Our ref: DOC19/913151
Senders ref: SSD-9472

Subject: EES comments on the Environmental Impact Statement for Sikh Grammar School –
SSD-9472 - 151-161 Tallawong Road, Rouse Hill

Subject: EES comments on the Environmental Impact Statement for Sikh Grammar School – SSD-9472 - 151-161 Tallawong Road, Rouse Hill

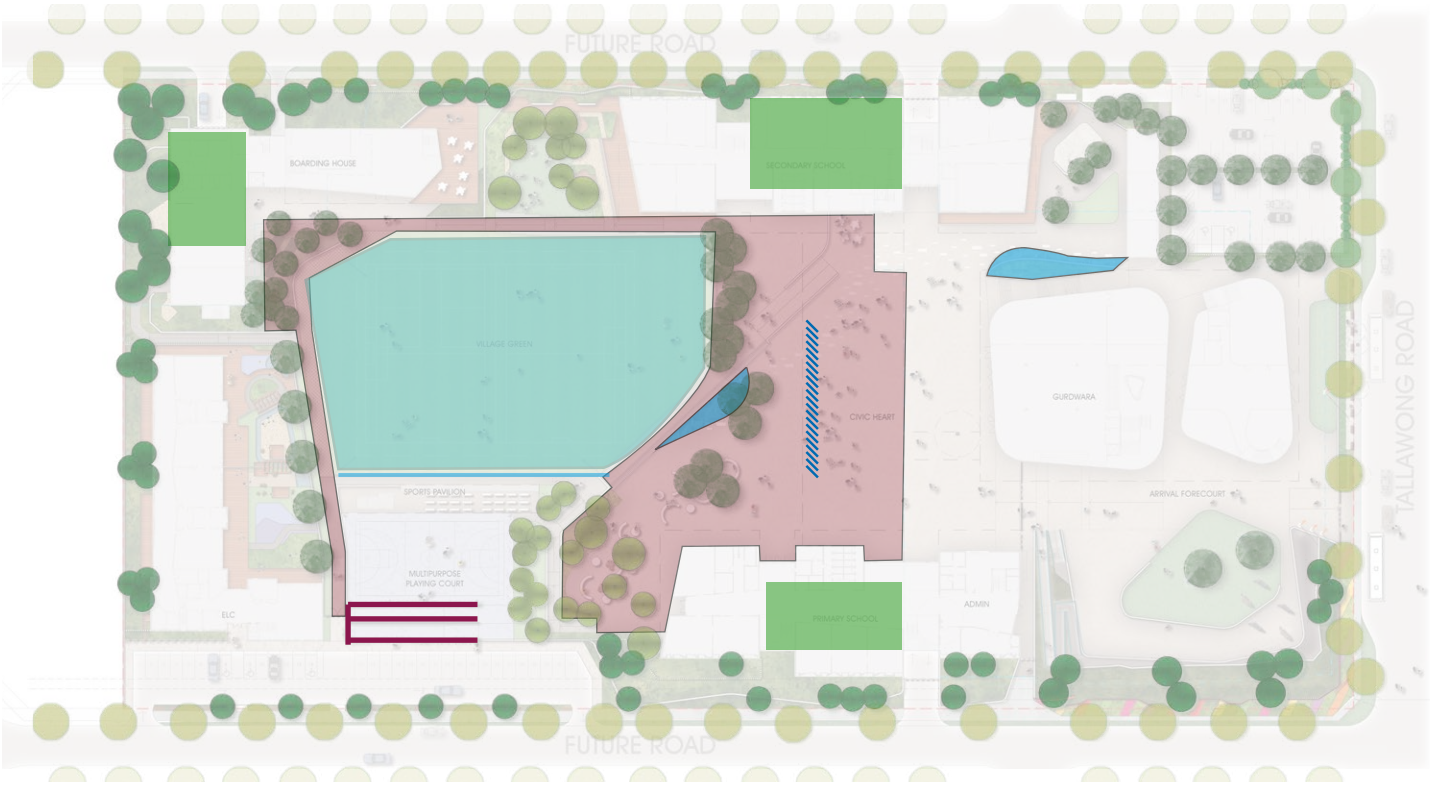
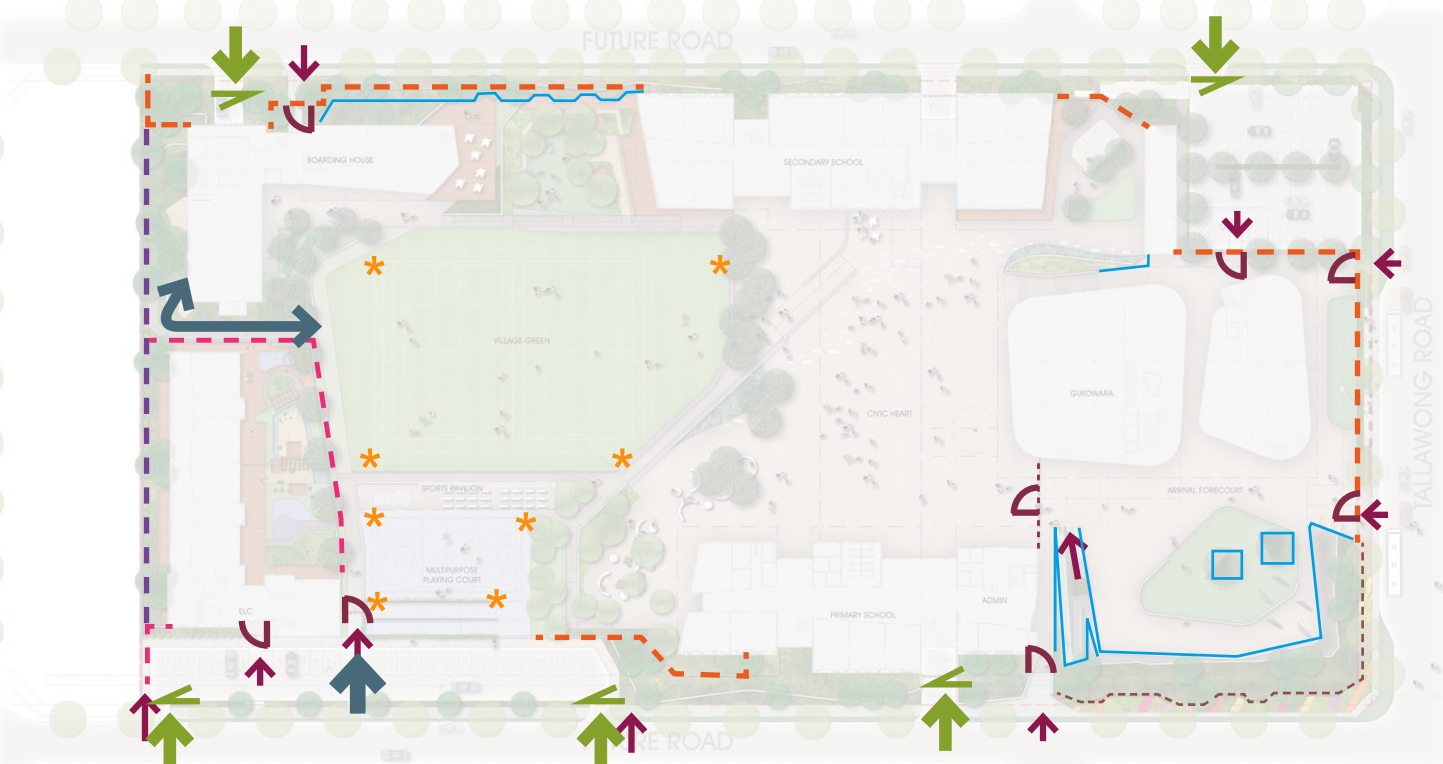
The Landscape Design Report appears to show that the 'village green' area on the site is proposed to consist of 'integrated permeable synthetic lawn' (see pages 8 and 9). It is recommended the Department considers potential issues associated with using synthetic lawn as opposed to using natural non-invasive lawn including:

- natural grass provides a cooler surface than artificial turf surfaces which get much hotter and absorb radiant heat (sunlight) and potentially add to the urban heat island effect by radiating the heat back into the air
- natural grass surfaces (as opposed to synthetic grass) provide some habitat value for certain native fauna.

PAINTING WITH THE LANDSCAPE - MASS PLANTING IN BLOCK COLOURS

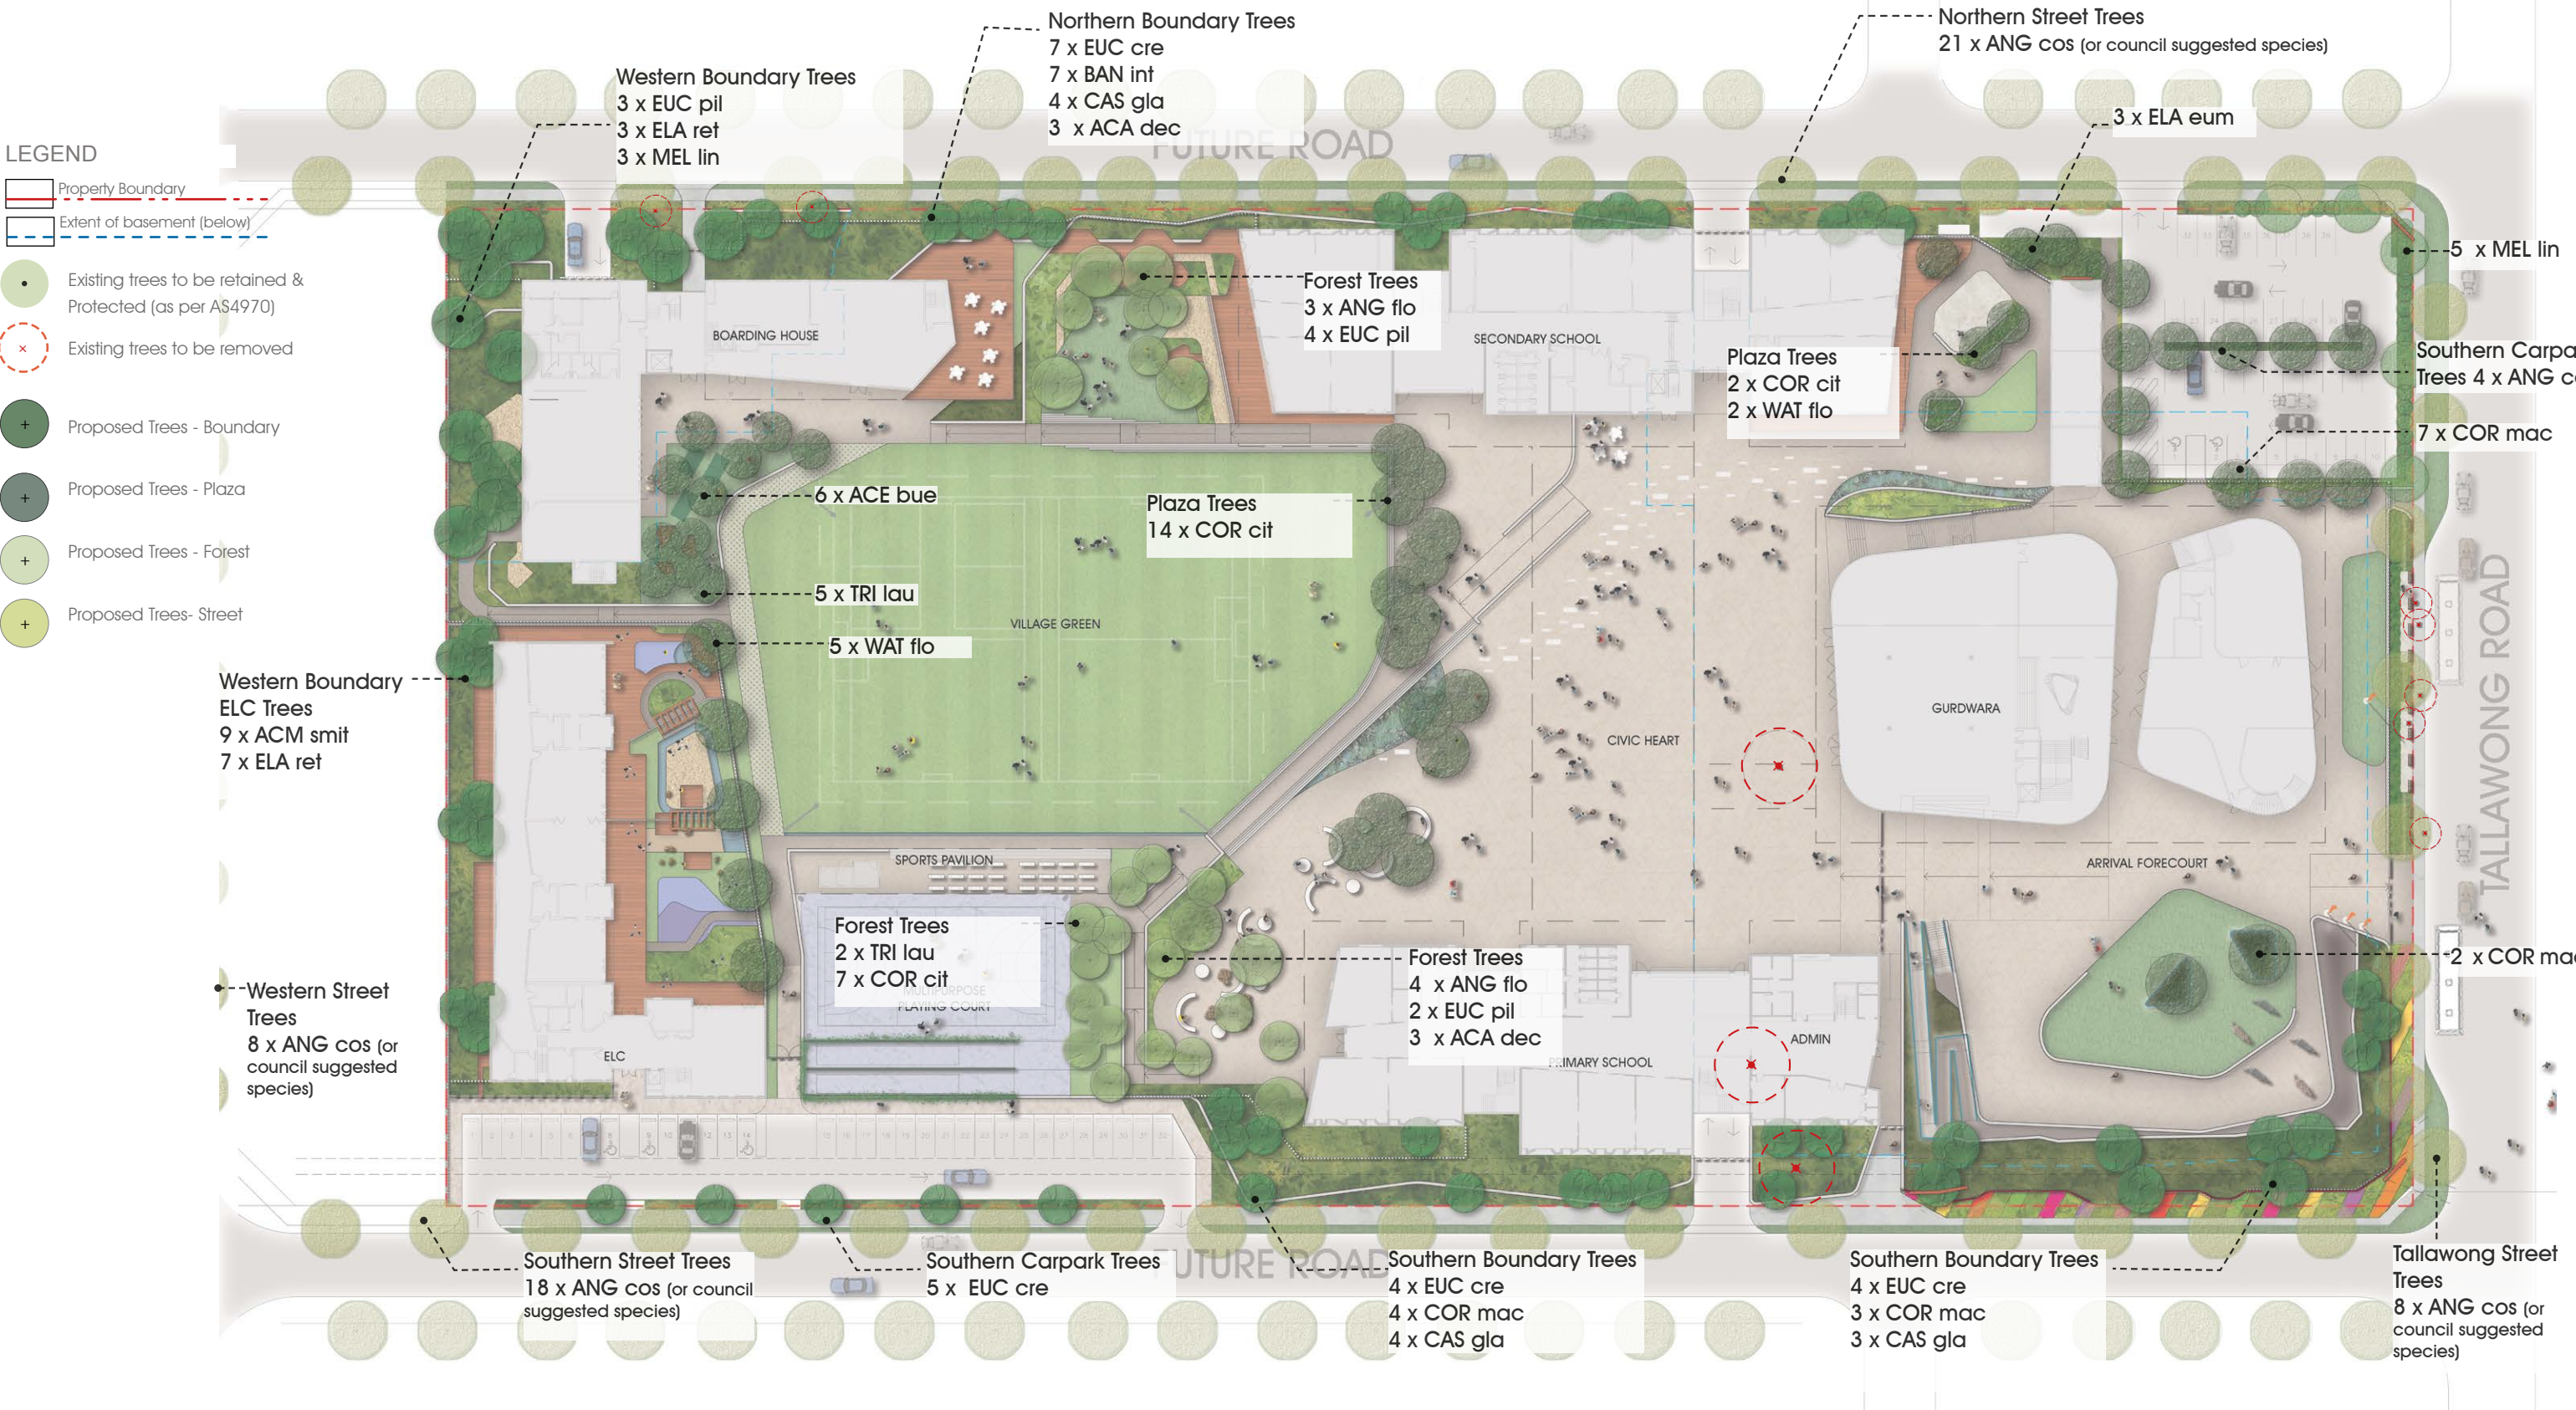
EES recommends that the plant species list used for tree planting should use species that are characteristic of Cumberland Plain Woodland, and that (according to the ATEAR) were found on site. This would include Narrow-leaved Ironbark (*Eucalyptus crebra*), Forest Red Gum (*E. tereticornis*), Rough-barked Apple (*Angophora floribunda*) and Grey Box (*E. moluccana*).

EES supports the inclusion of the Rough-barked Apple as a species to be used in planting, in reference to the Darug word 'dalawong' (as mentioned in section 3.2.4 of the EIS) but it should be noted that the Rough-barked Apple is *Angophora floribunda* not *A. costata* (Smooth-barked Apple) EES notes the Landscape Design report also proposes to use *A. costata* (Smooth-barked Apple) (pages 2 and 14). The Smooth-barked Apple is found in sandstone environments, and so it is not suitable for the site. It is recommended *Angophora costata* (Smooth-barked Apple) is removed from the species list.

EES recommends the indicative plant schedule is amended to use a diversity of local provenance species (trees, shrubs and groundcovers) from the native vegetation community that occurred on the site rather than use non-endemic native species and exotic species.
